From: Jean Fraser
To: Greer, Tom
CC: Barhydt, Barbara; Benn, Jeremy; Margolis-Pineo, David
Date: 1/8/2014 3:59 PM
Subject: cobbles at 133 York Street project
Attachments: Cobbles at 133 York.jpg

Right from the beginning there appeared to be agreement that it would be good if the cobbles could stay and I know you have tried several options for this as its complicated by the city's "materials" policy. The Planning Board was encouraging further consideration of the possibility of keeping them in the project.

C1.1

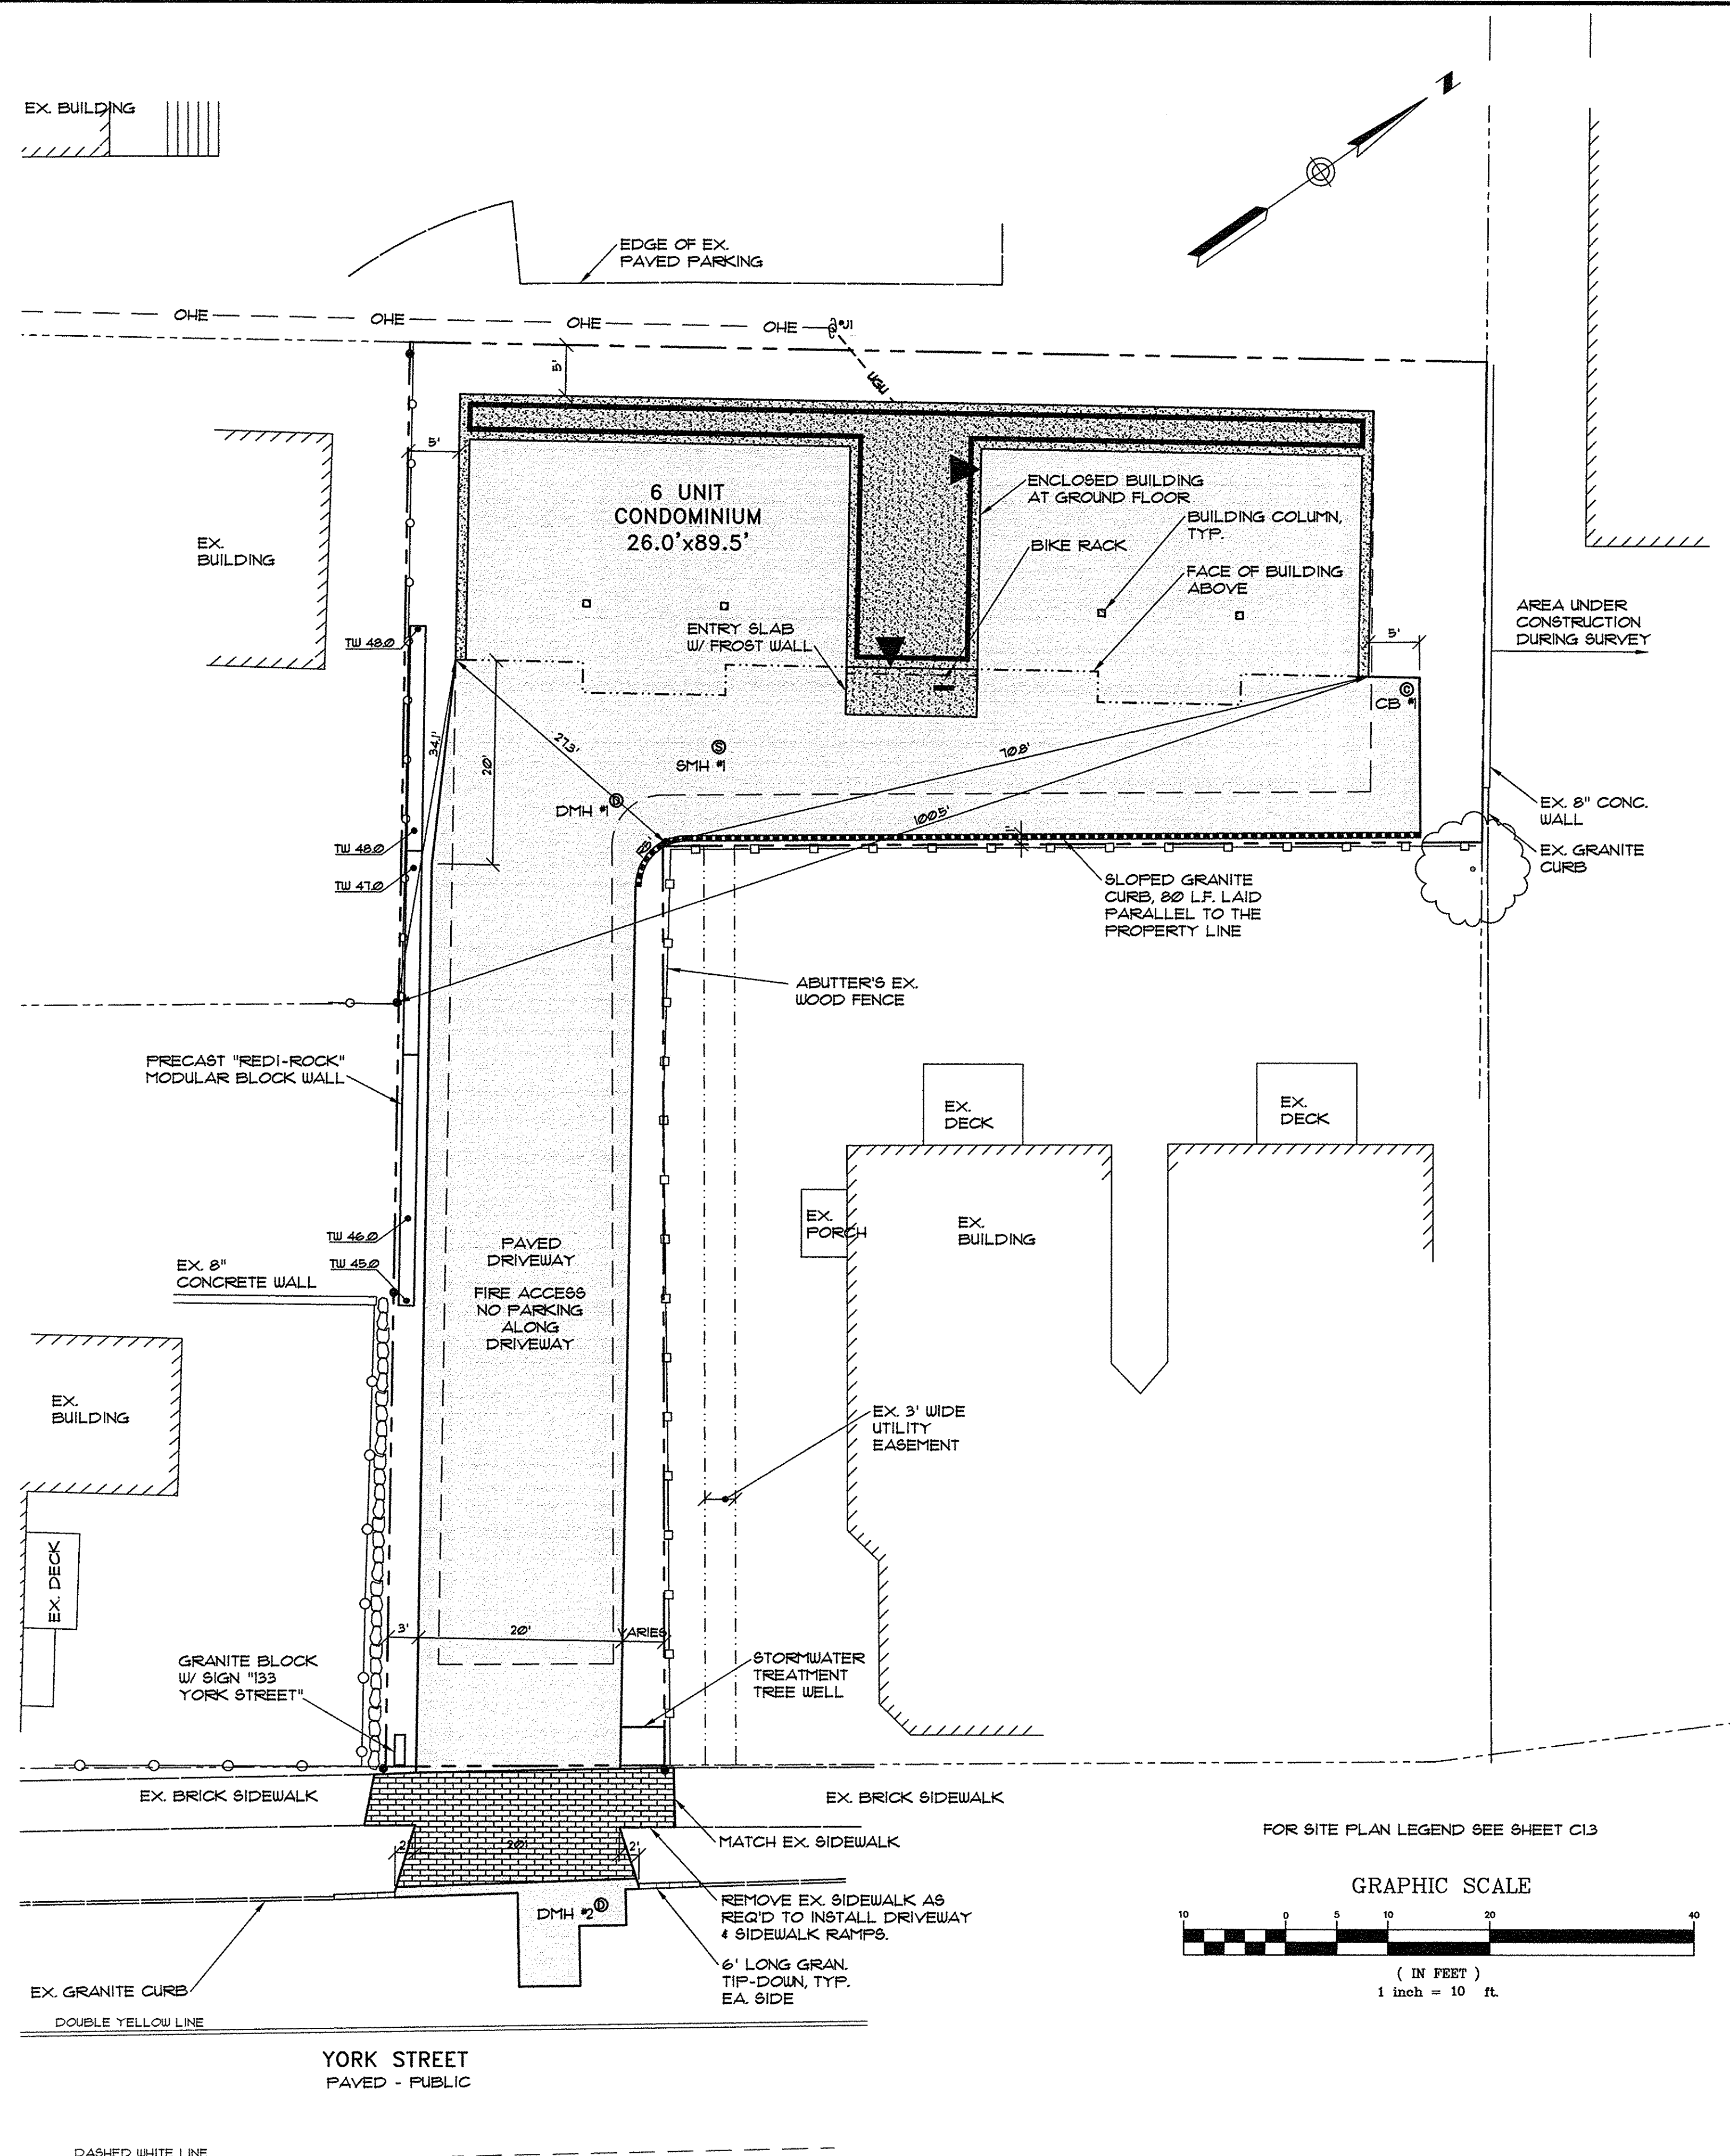
David Margolis-Pineo of DPS has confirmed that the City would sell the cobbles for \$2 each. I have done a quick count (see attached photo) and it looks like about 400 cobbles or approx \$800 to buy. From that cost I think you could subtract the cost of the top coat material for an equivalent area.

It does not seem a huge sum and I would encourage the applicant to buy the cobbles and reuse them as you showed on an earlier plan ie on the private property right next to the sidewalk. That would avoid having to go to the City Council for an approval of them being in the ROW. Hope that can be considered.

I have met with all the neighbors or have communicated with them. They seem to be on board with the new look of the building and the easements. Once they get back to me I will update you. As for the cobbles a cost would be helpful. As of now, we do not intend to use them so they would go to the city. That could change.
